Re: PA23-005 – Creekside PRD – Technical Review 1
7808 40th Street, 7811 & 7715 40th Street NE, APNs 29050200100200,
29050200100300, and 29050200100400

BINDING SITE PLAN / PLANNED RESIDENTIAL DEVELOPMENT COMMENTS

APPLICANT:  
**HORIZON VIEW HOLDINGS, INC.**  
6443 NE 181ST ST  
KENMORE, WA 98028  
CONTACT: DANIEL WICK  
(206) 551-0499

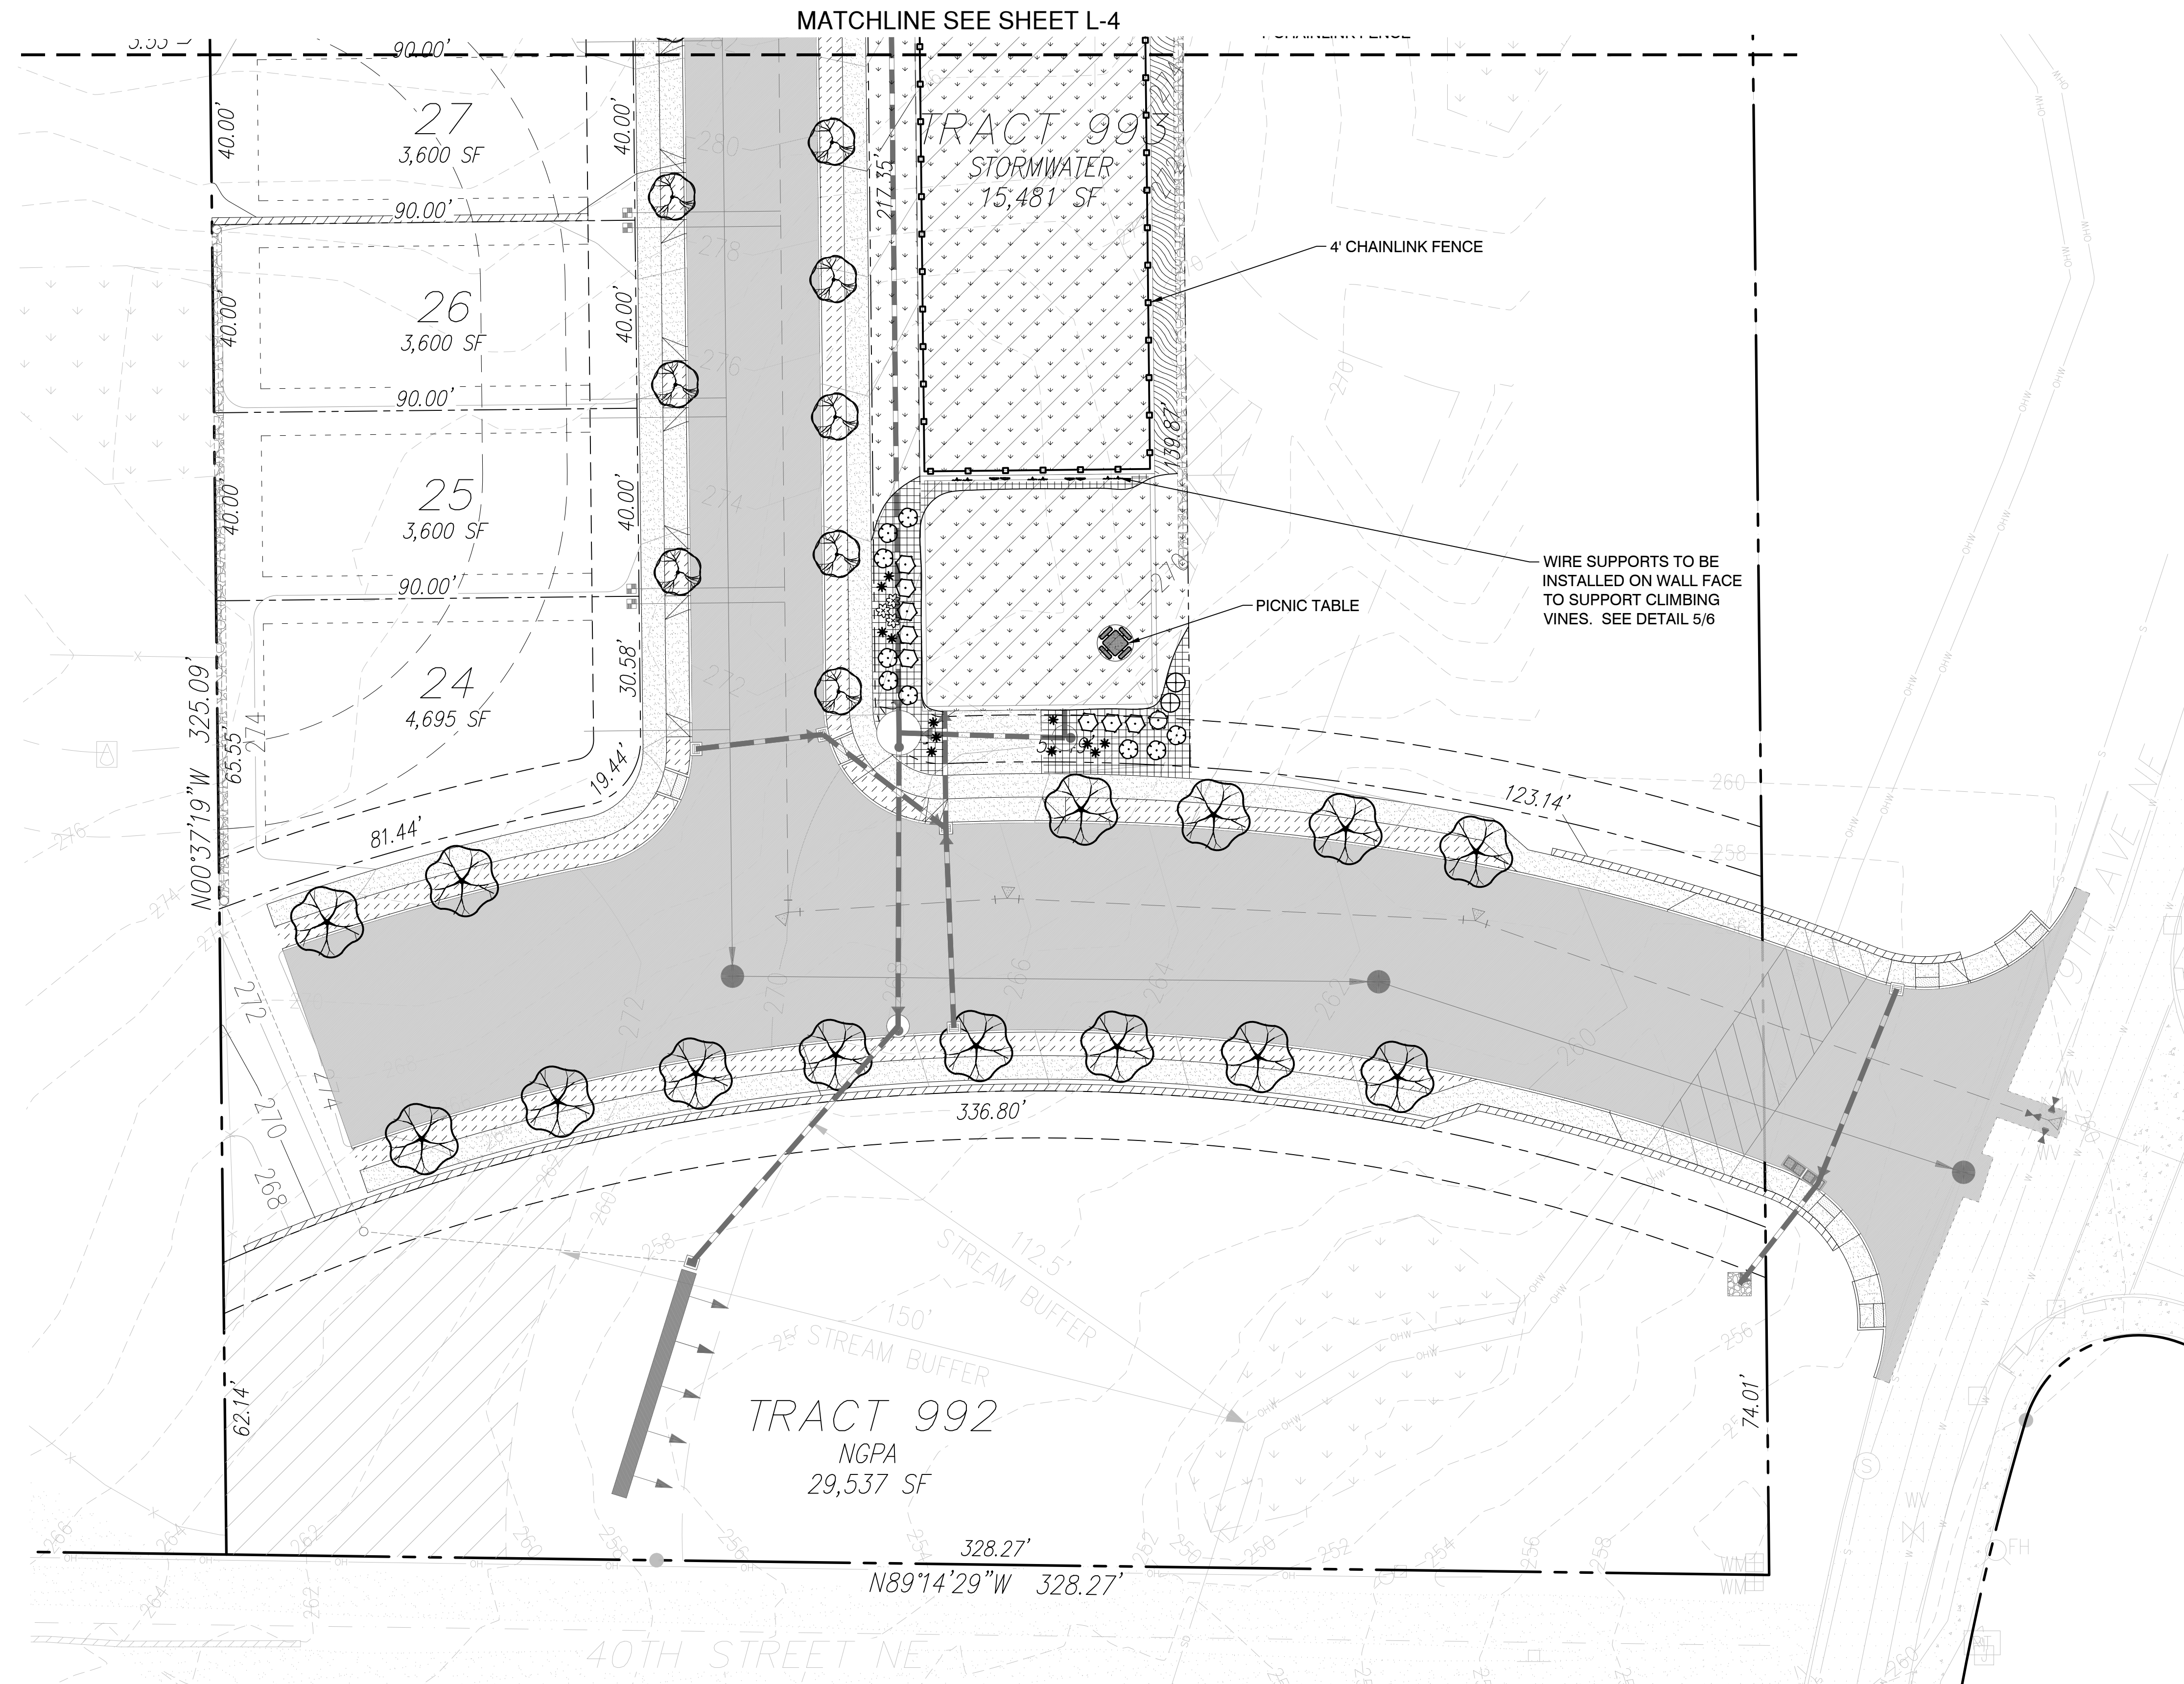
18. Chain link fences are not permitted within the East Sunnyside Whiskey Ridge subarea. Please amend the site plan to include this prohibition. Please revise the landscape plan to incorporate and different type of fencing.
19. The vault in tract 993 shall comply with the 15' setback (see comment 13.1 above).

20. A final landscape plan shall be required to be approved, prior to civil construction plan approval, and designed to comply with the applicable provisions outlined in [MMC Chapter 22C.120, Landscaping and Screening](#). **Specifically, please revise the Landscaping Plan to include:**

20.1. Typical side view of perimeter landscape areas, specifically the proposed 10 ft. landscape easements.

20.2. Perimeter plantings for open space tracts.

PP-01
 SHEET 1 OF 3

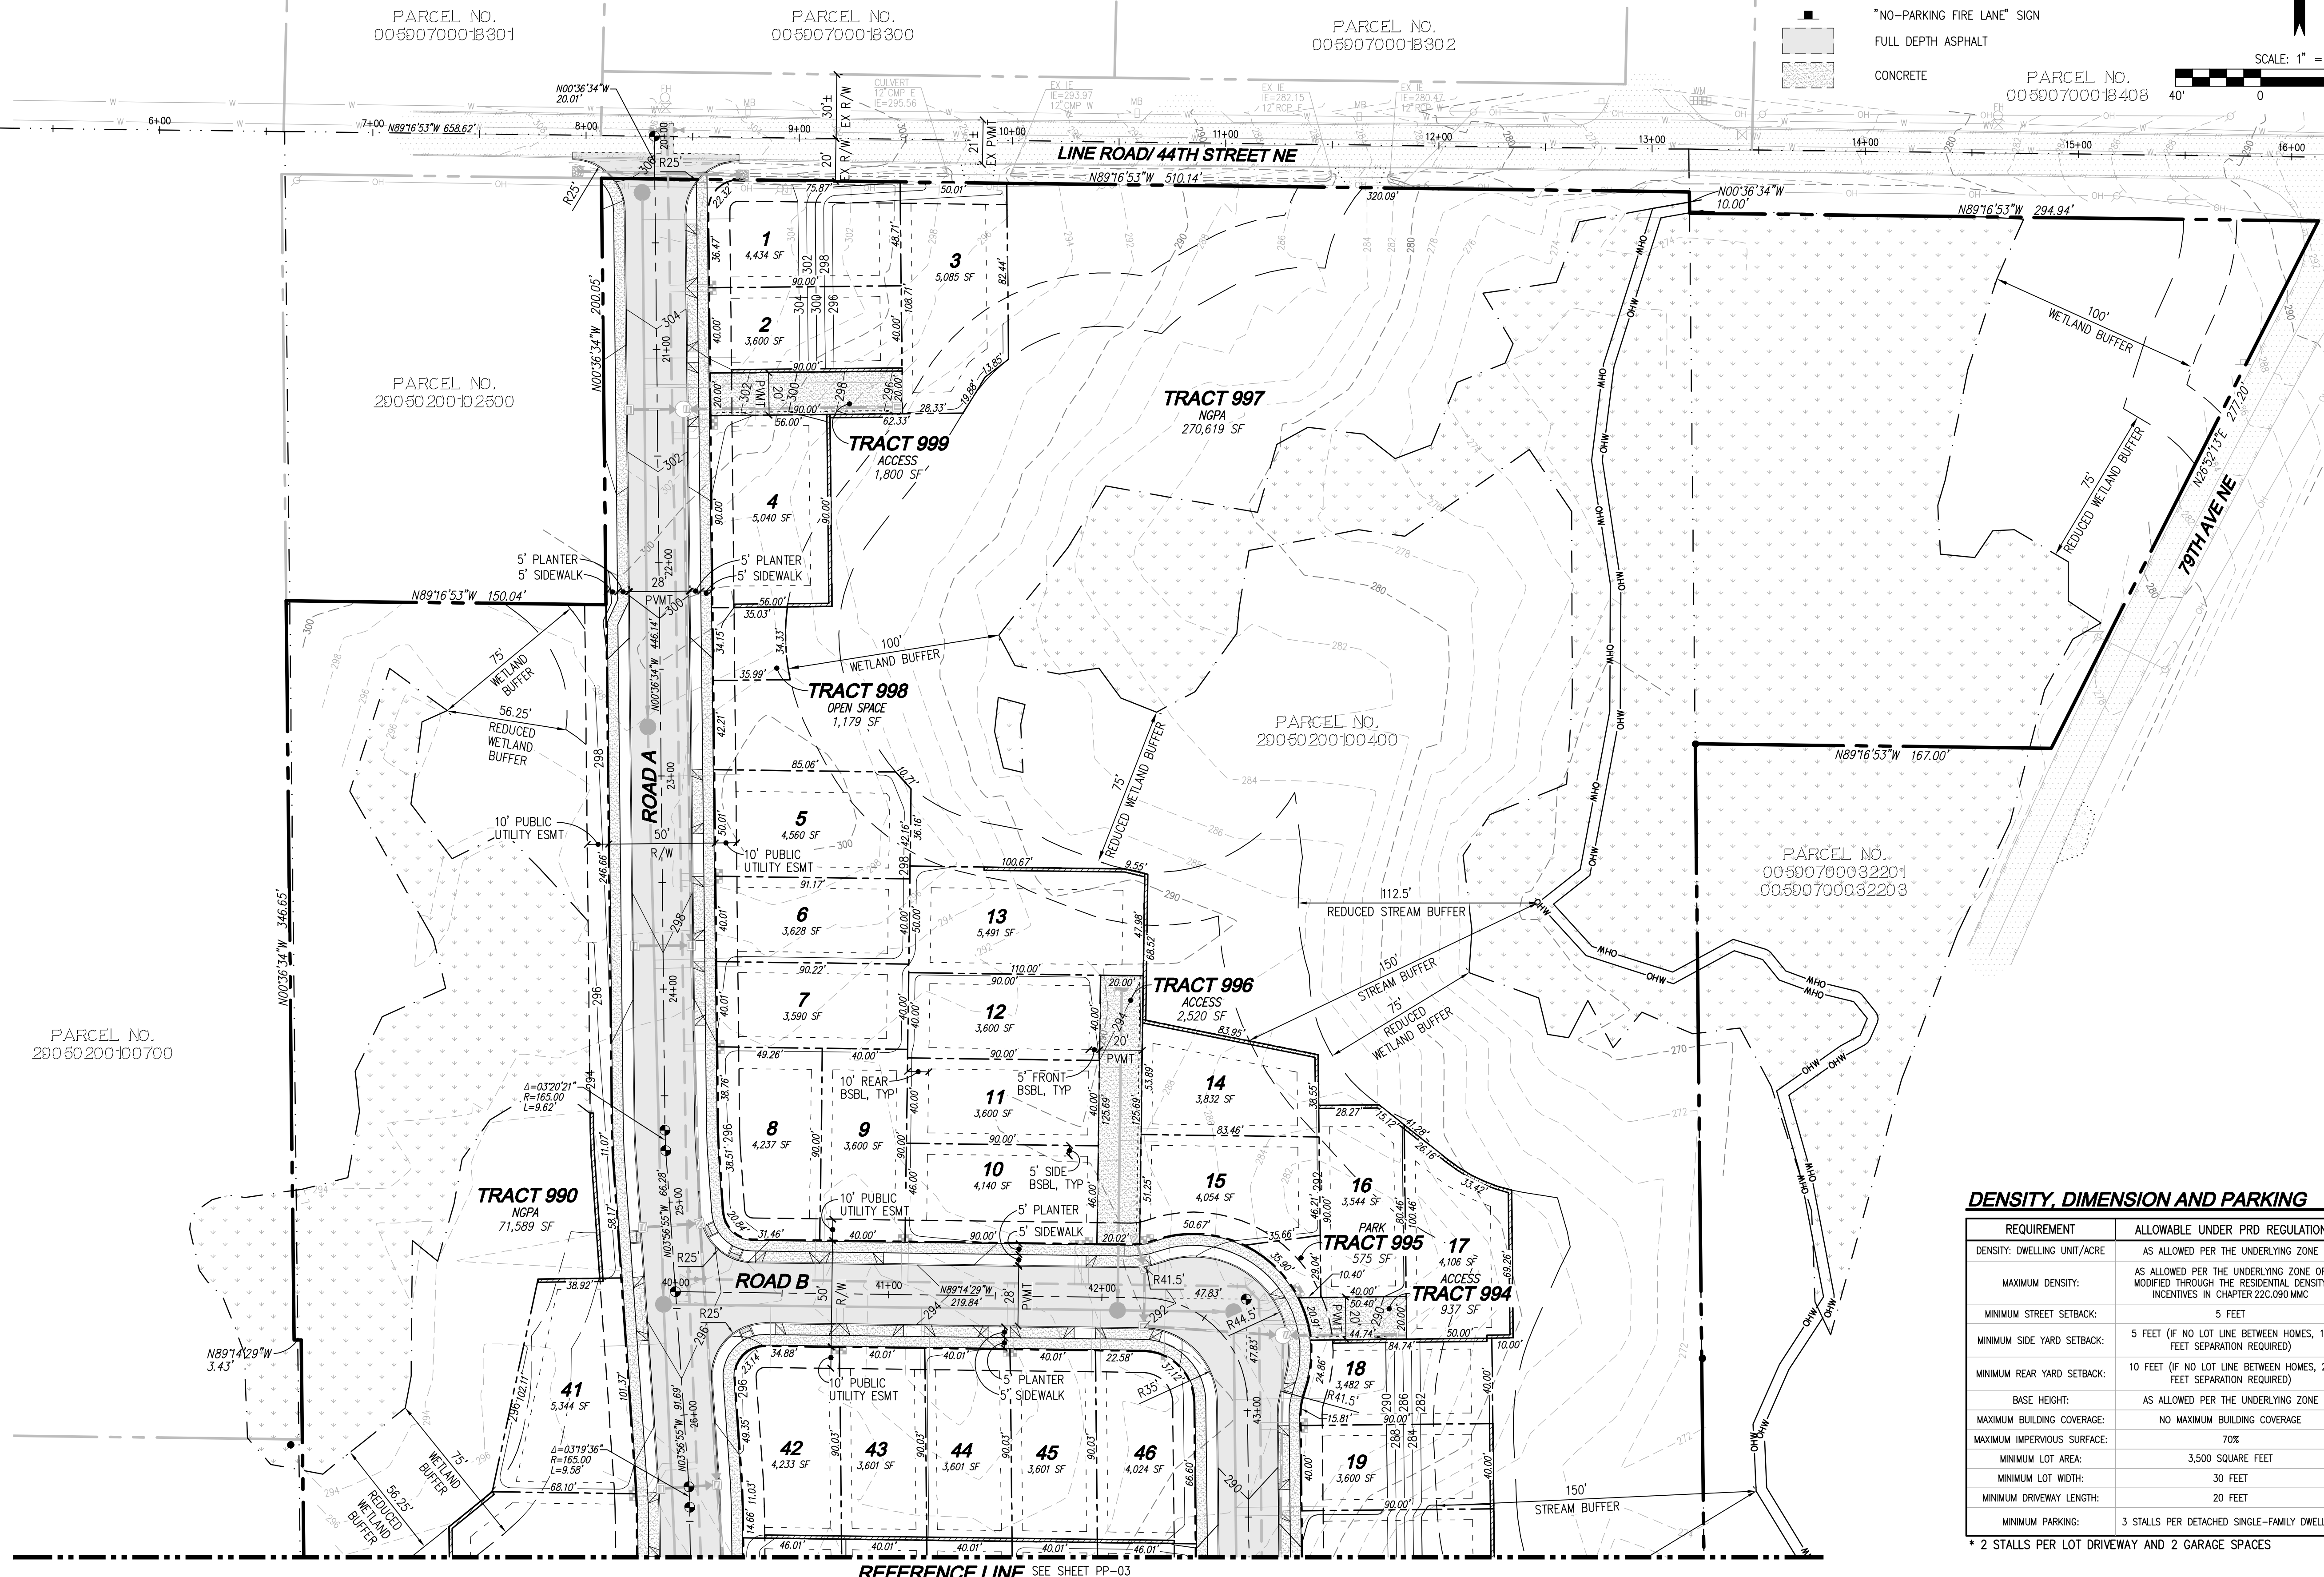
4. Bulk and dimensional standards for a PRD are outlined in [MMC 22G.080.080](#). Please revise the table on sheet 2 of the Preliminary Site plan to comply with these standards (street setback is incorrect, and no setback from NGPA or critical areas is listed).
5. Minimum lot size in a PRD is 3,500 SF. Lot 18 does not meet the minimum lot size, please revise.
6. Minimum street setback in a PRD is 10 feet. Please revise lots 34-37 to meet this requirement.
7. Building setbacks from critical area buffers/NGPA tracts shall be 15 feet. Please review and revise setbacks on lots that do not meet this requirement (Lots 3, 4, 5, 13, 14, 16, 17, 18-23, 24-35, 37, 39, 40, 41, and others).

8. Rear yard setbacks in a PRD are 10 feet. Please revise lots 42-46 and 47-51 (any others as necessary) to meet this requirement.
9. Minimum lot size in a PRD is 3,500 SF. It appears that lots 3, 4, 5, 13, 14, 17, 71 and possibly others can be reduced in size to encroach less in to the buffer and decrease the negative impact. The proposal shall be consistent with [MMC 22E.010.110](#). Please review all lots within buffers or proposed reduced buffers and reduce to have the least impact on critical areas and associated buffer.
